OXFORDSHIRE COUNTY COUNCIL'S RESPONSE TO CONSULTATION ON THE FOLLOWING DEVELOPMENT PROPOSAL

Application no: 22/02025/REM

Proposal: Reserved Matters to 16/02586/OUT - Access, layout, scale, appearance and landscaping details for Phase 1B for up to 12 No knowledge economy units in Use Class E (former Use Class B) (14,972 sq m gross external area) with associated parking, landscaping, utilities and access

Response Date: 18th October 2022

DRAWING NUMBER: **226701_PD01** REVISION: .

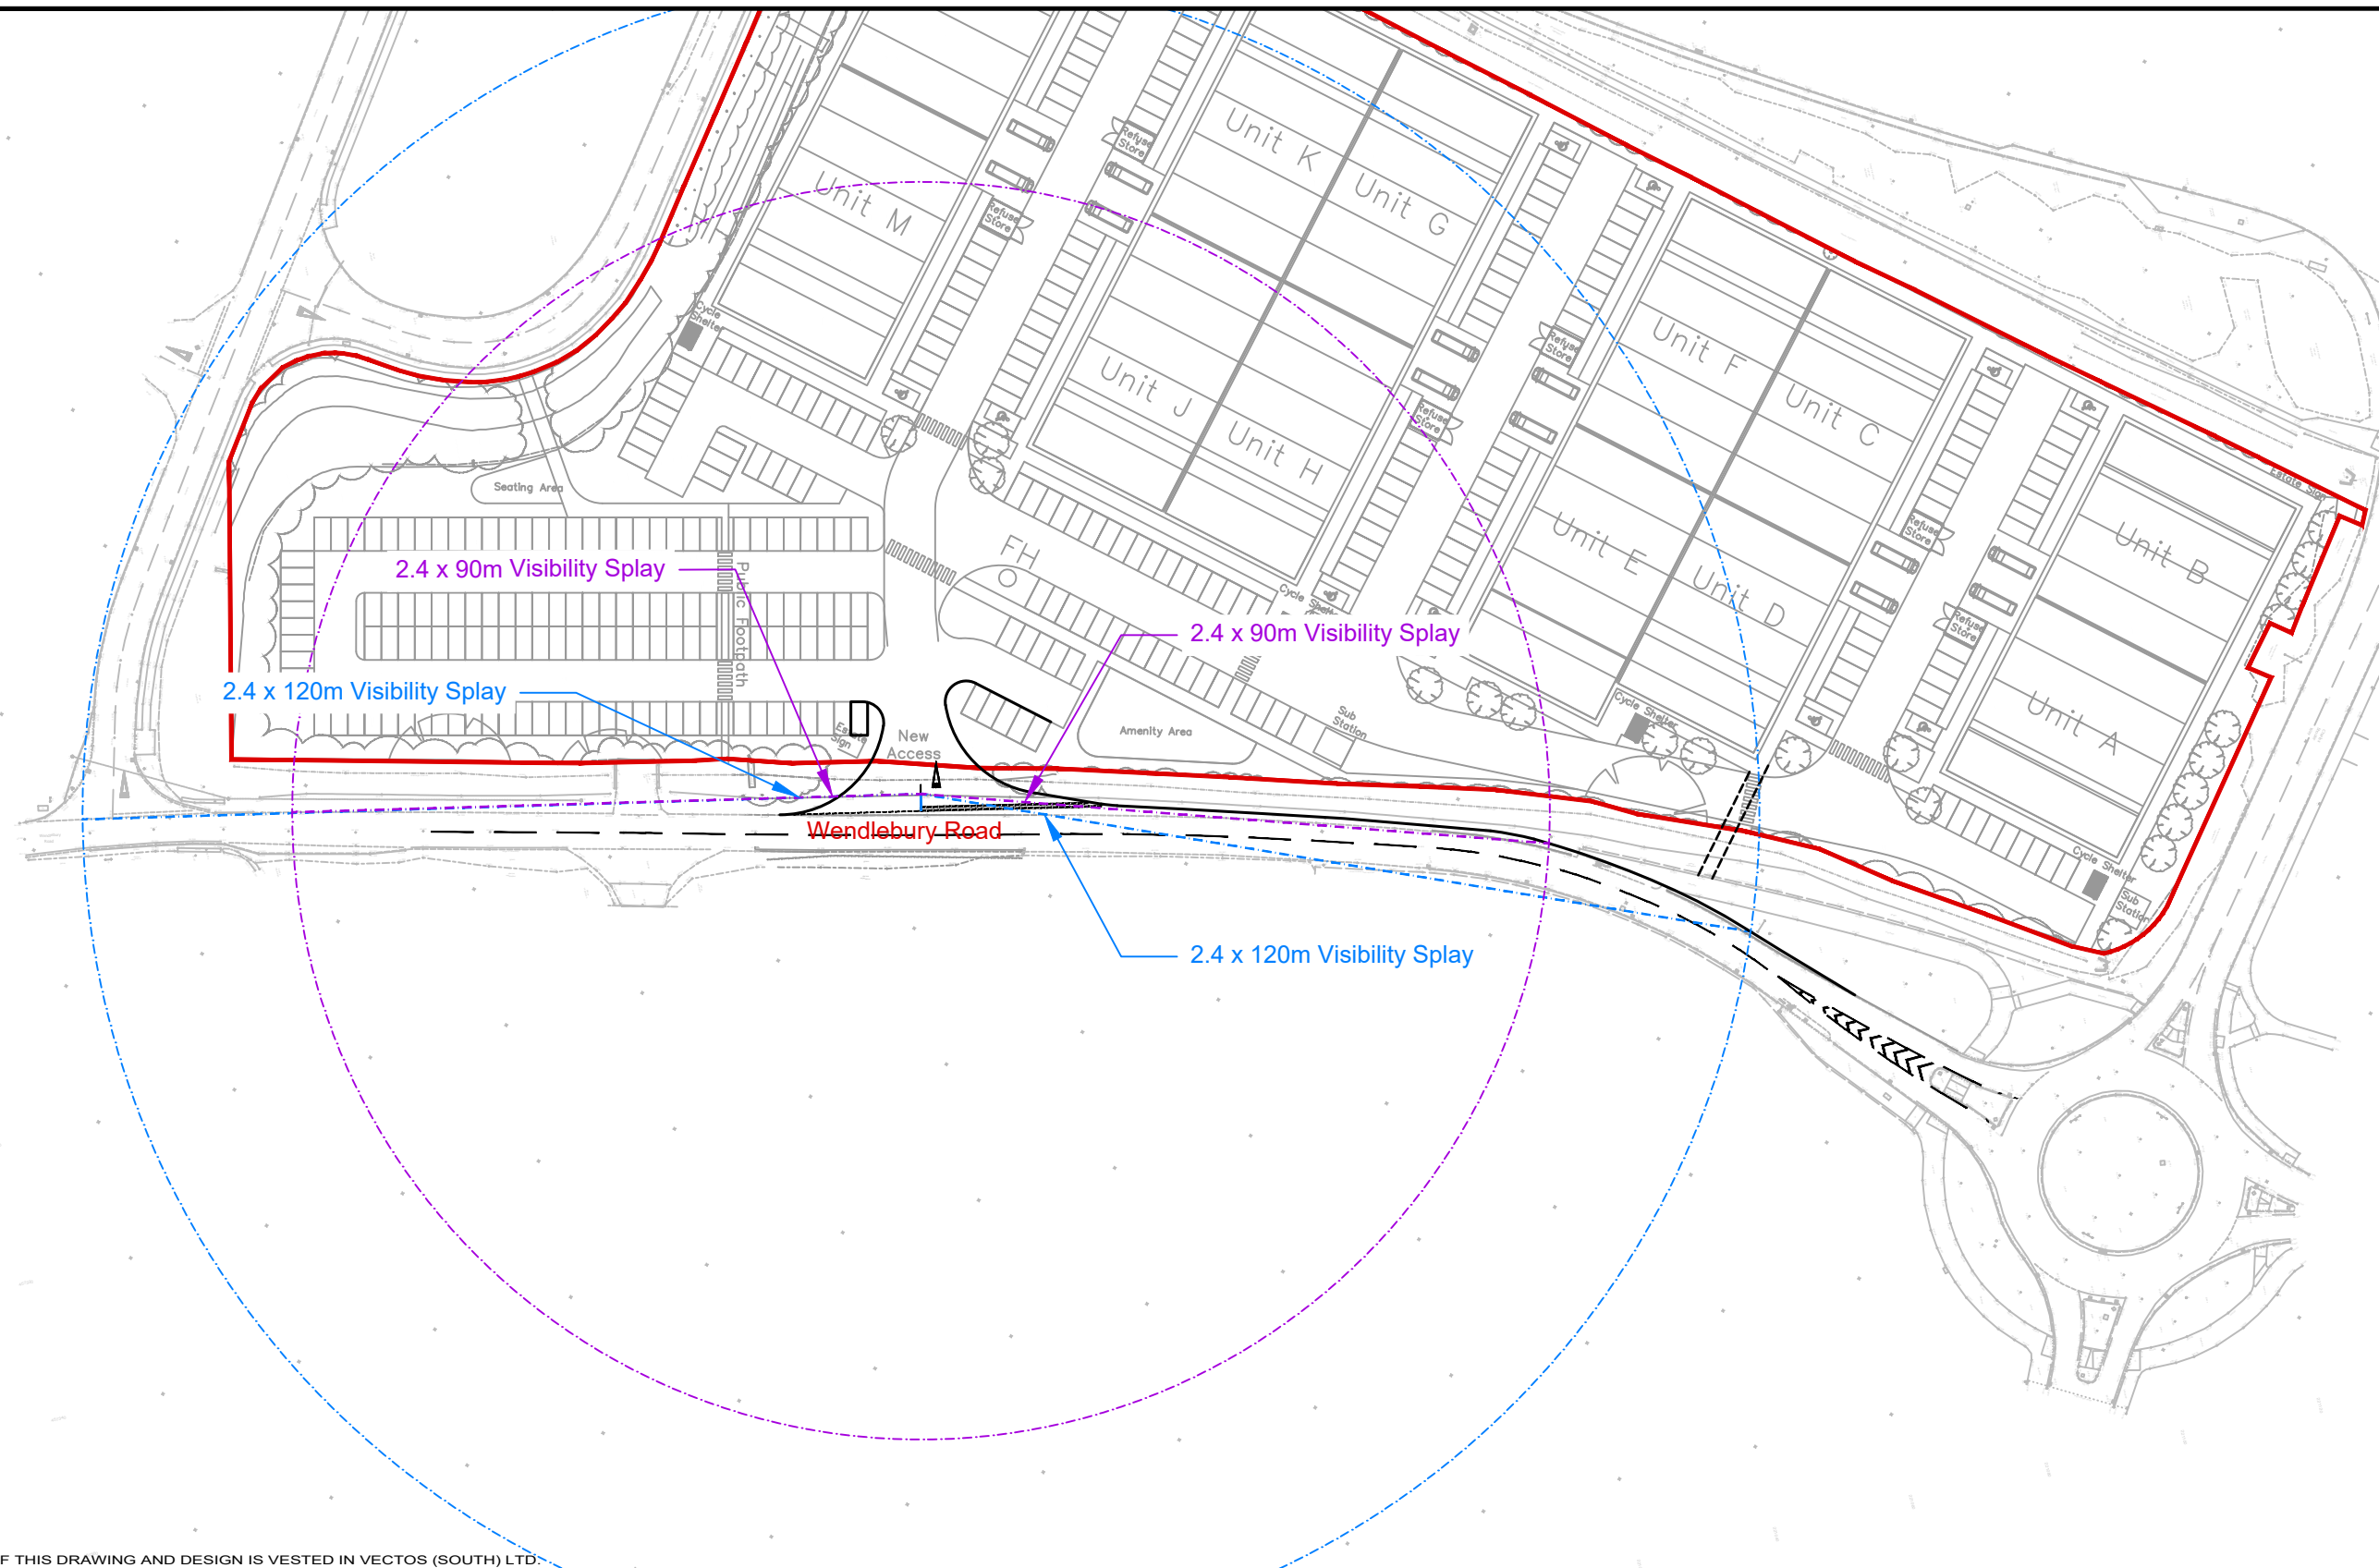
It is noted that cycle provision is to be provided on to the A41. However, this is not likely to be the sole route for cyclists.

As listed on the drawing the Wendlebury Road is a Cycle Route which cyclists will continue to use. This is also shown on the drawing where the cyclist marking is shown to rejoin the shared footway/cycleway.

Therefore as this is still a route to be utilised the County requests that the developer extends the footway/cycleway across the frontage to the below access. The cycleway across the new access should be a set back design. The cyclists would then be able to leave and re-join the carriageway in the location below.

This matter remains a reason for objection.
